**From:** Contact Centre (CRM) <contact@ribblevalley.gov.uk>  
**Sent:** 11 April 2024 10:40  
**To:** Planning  
**Subject:** Planning Application Comments - 3/2024/0096 FS-Case-604805918

**Planning Application Reference No.:** 3/2024/0096

**Address of Development:** Longridge High School  
Preston Road  
PR3 3AR

Site Plan (Scale 1:1250)

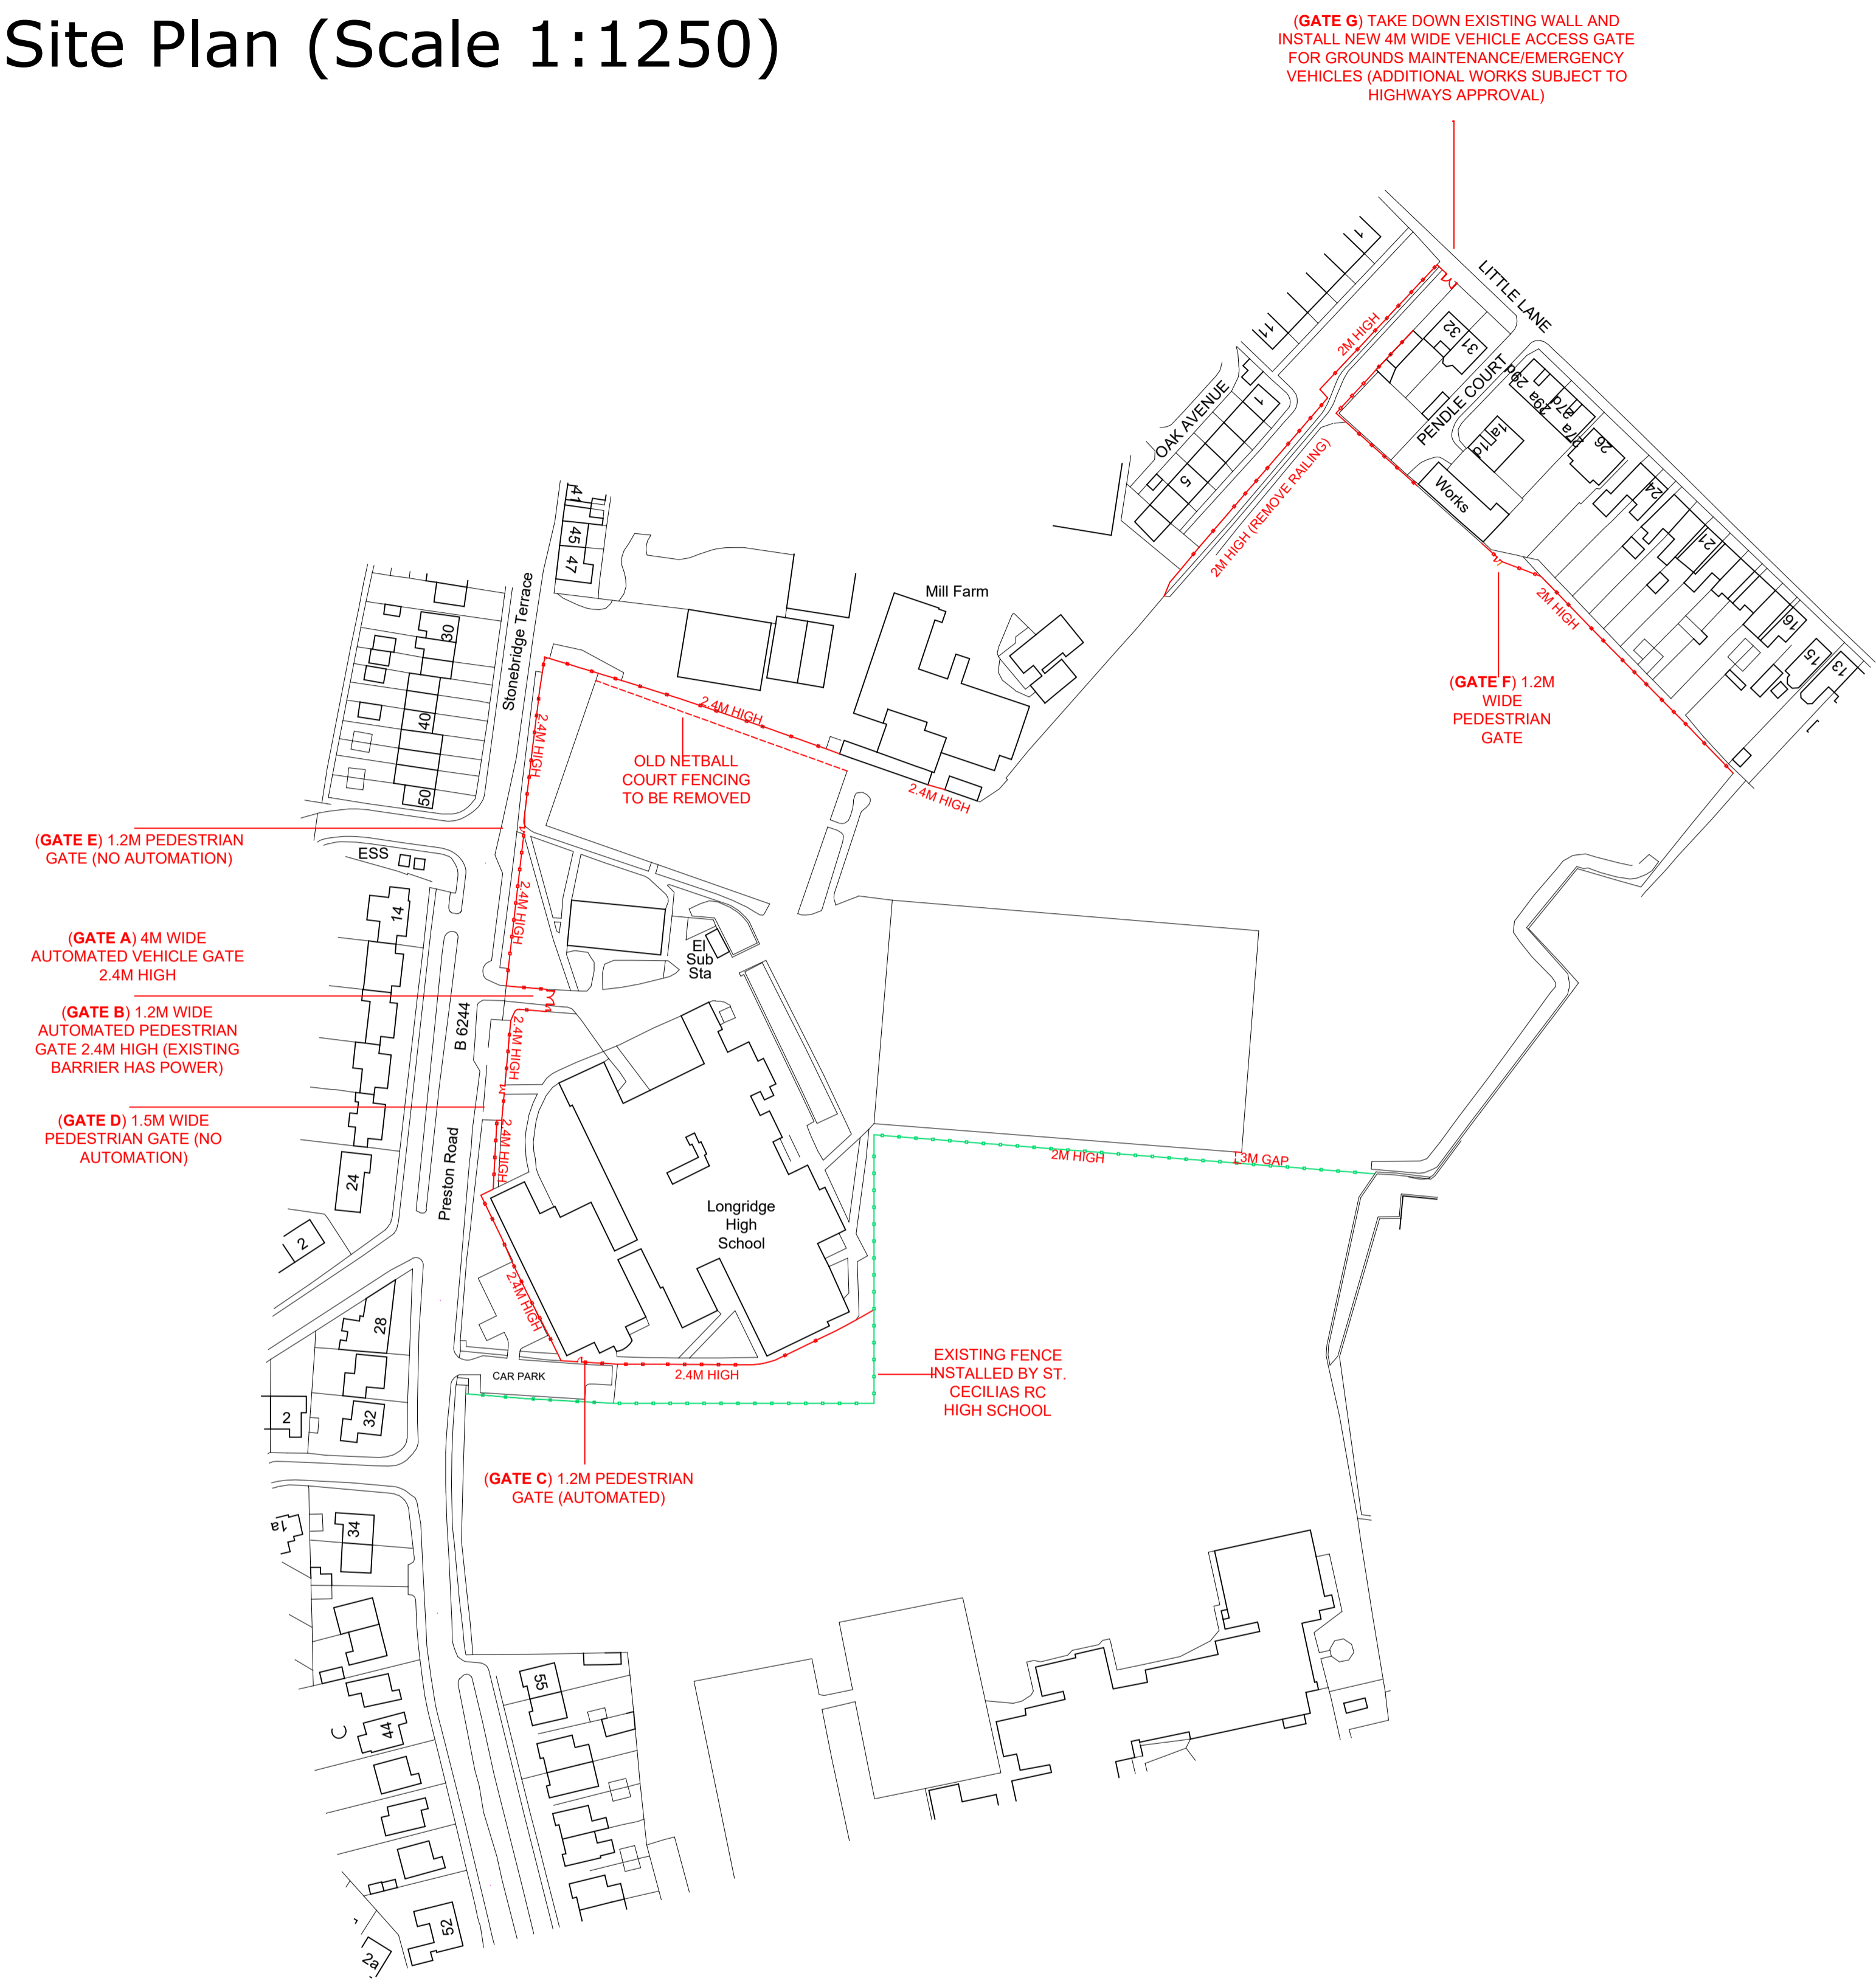
**Comments:** I am concerned that this fence will be an eyesore and, unless it is required for student safety, planning should be denied. Longridge high school is bordered by two conservation areas and this fence is not in keeping.

If the fence is a legal requirement for the school I think it should be set back slightly and sensible planting placed in front to soften the impact.
